Your Ref: OWPC18039
Our Ref: R/73/18/HH 30-03-2018
Please ask for:
Amber Willard

Rear single storey extension
56 North Lane Rustington

| REVISIONS                                                                                                                                                     |                             |
|---------------------------------------------------------------------------------------------------------------------------------------------------------------|-----------------------------|
| DRAWING<br>PLANNING<br>DATE: MARCH 2018<br>DRAWN: T. Murray                                                                                                   | SCALE<br>1/100<br>REVISION: |

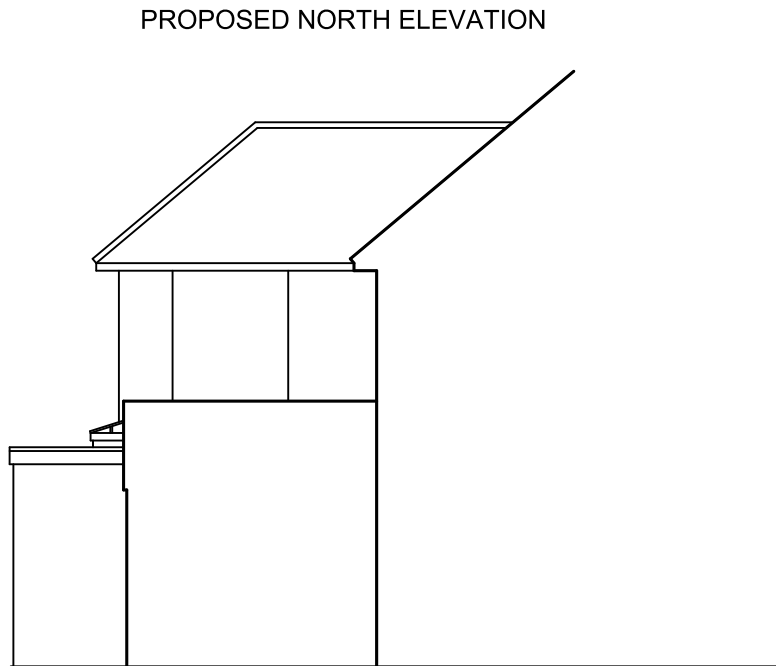
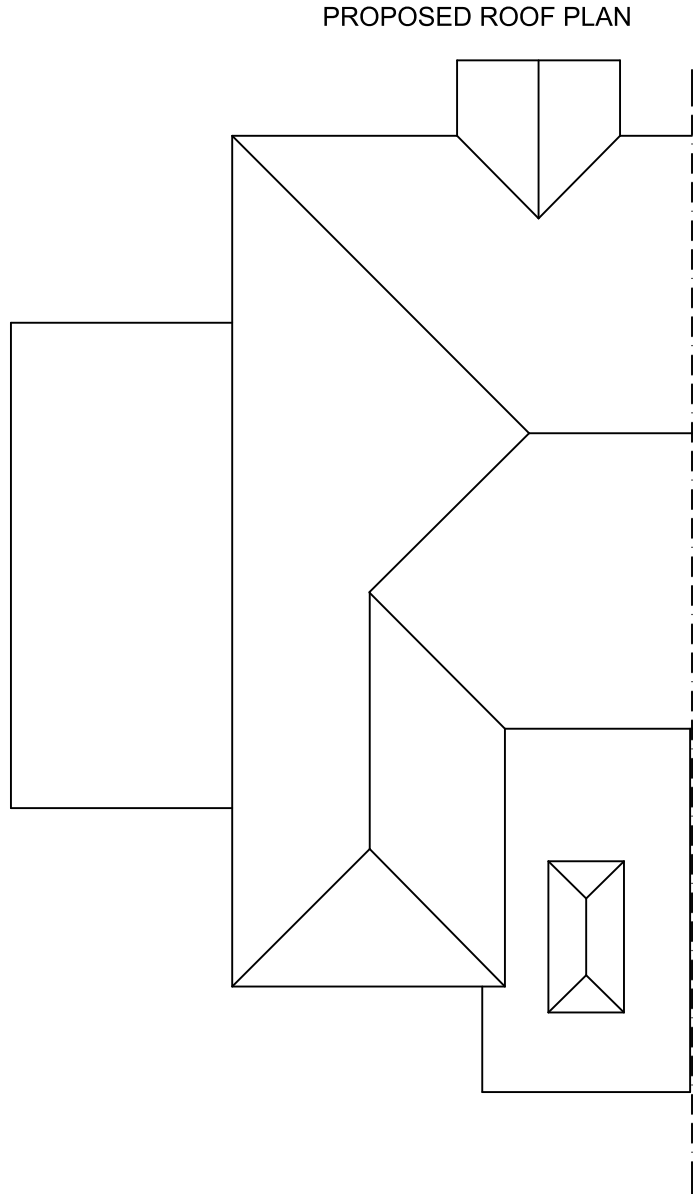
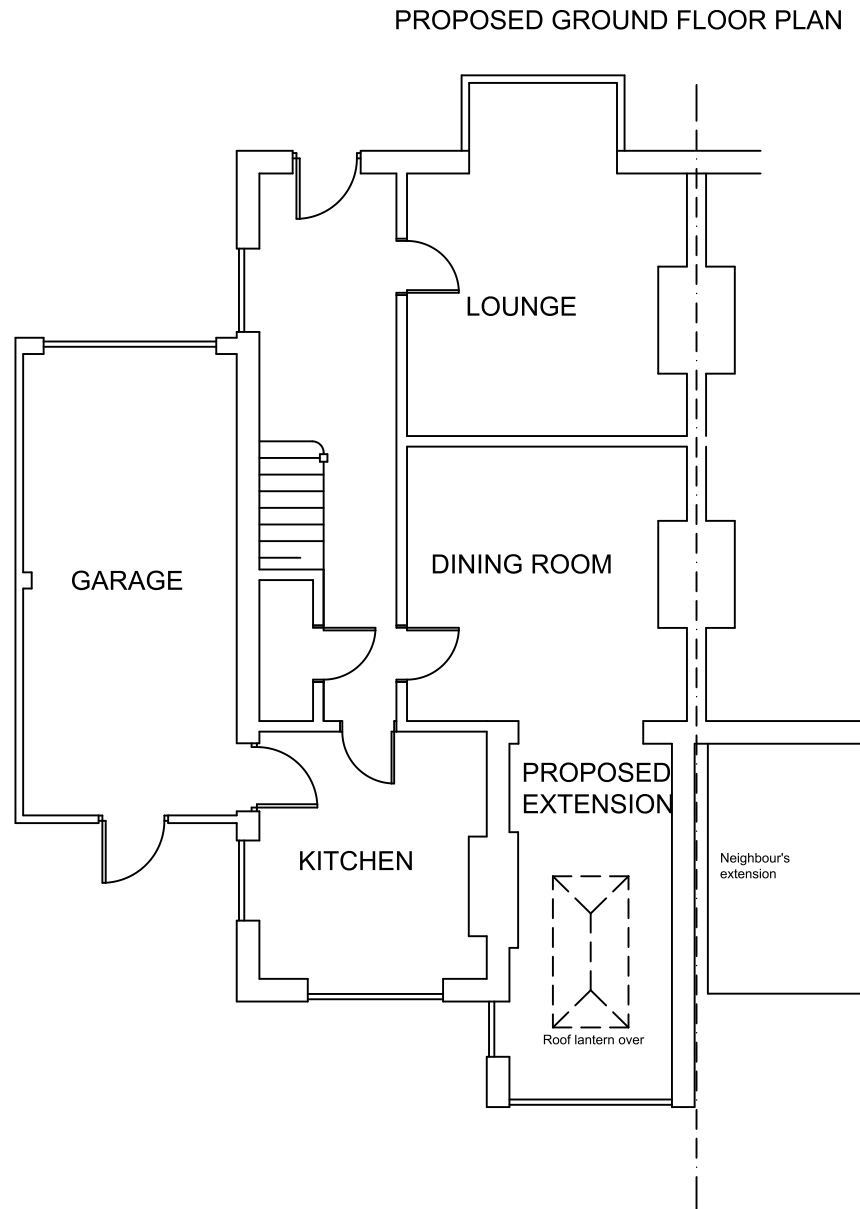
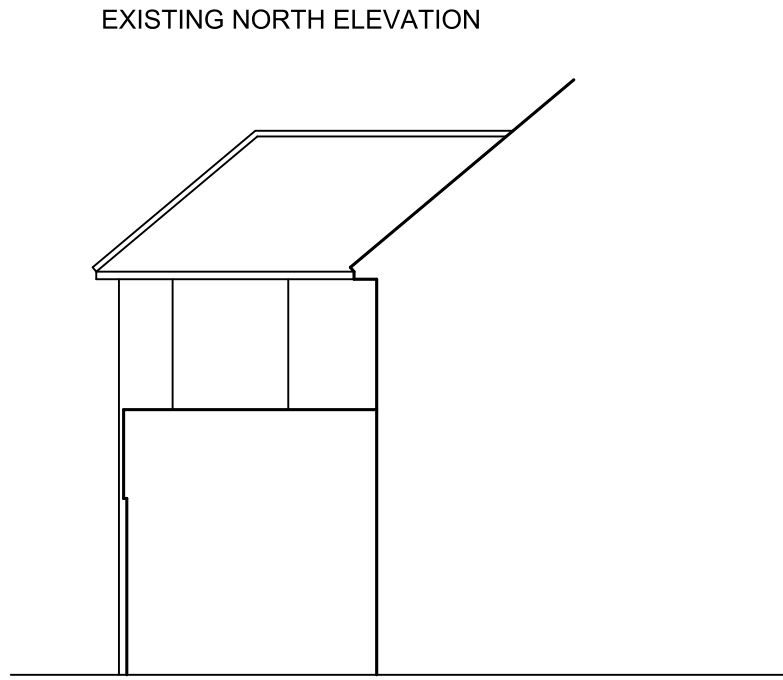
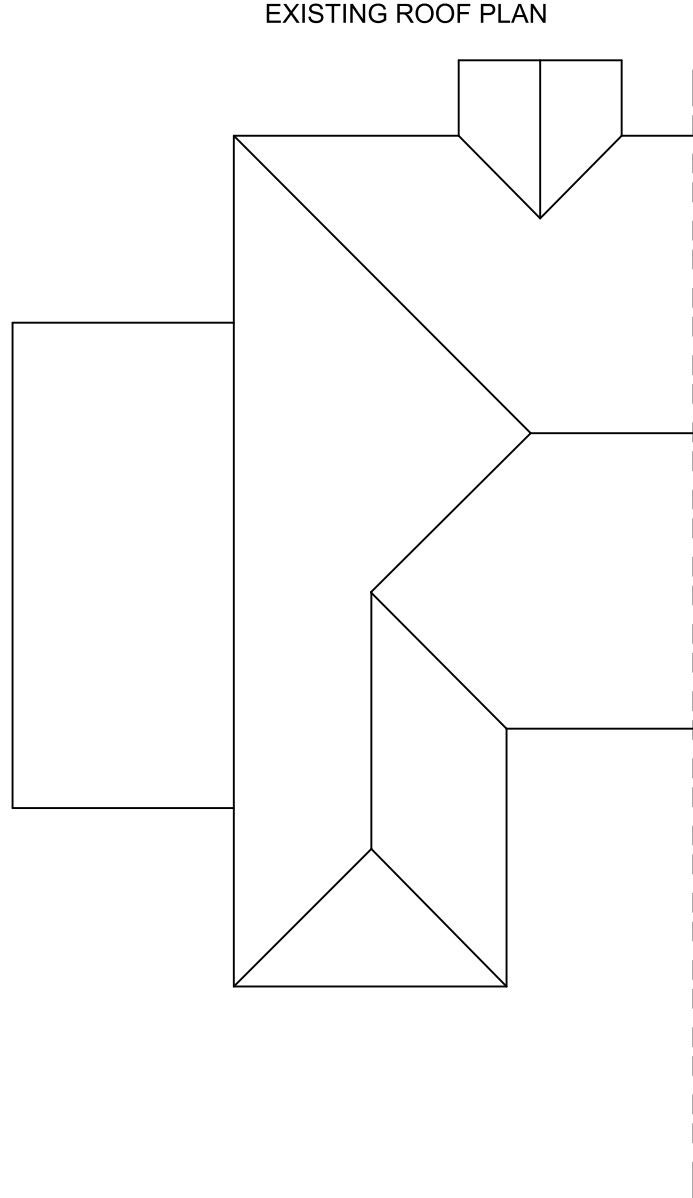
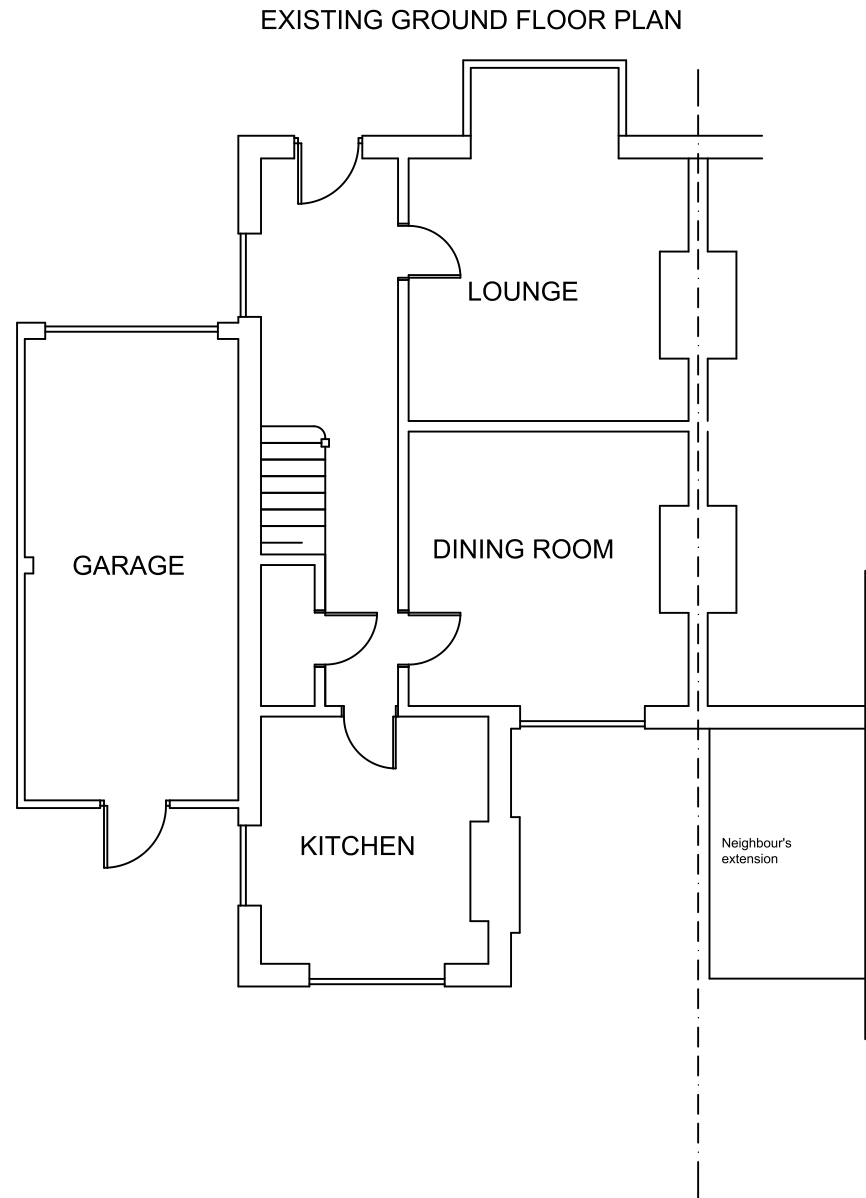
The proposed extension is considerably longer and higher than our own and will inevitably reduce the light to our property which was one of the main reasons we built ours in the first place. We are also concerned that debris will build up in the small gap between the two walls that will eventually cause a problem with damp on both sides.
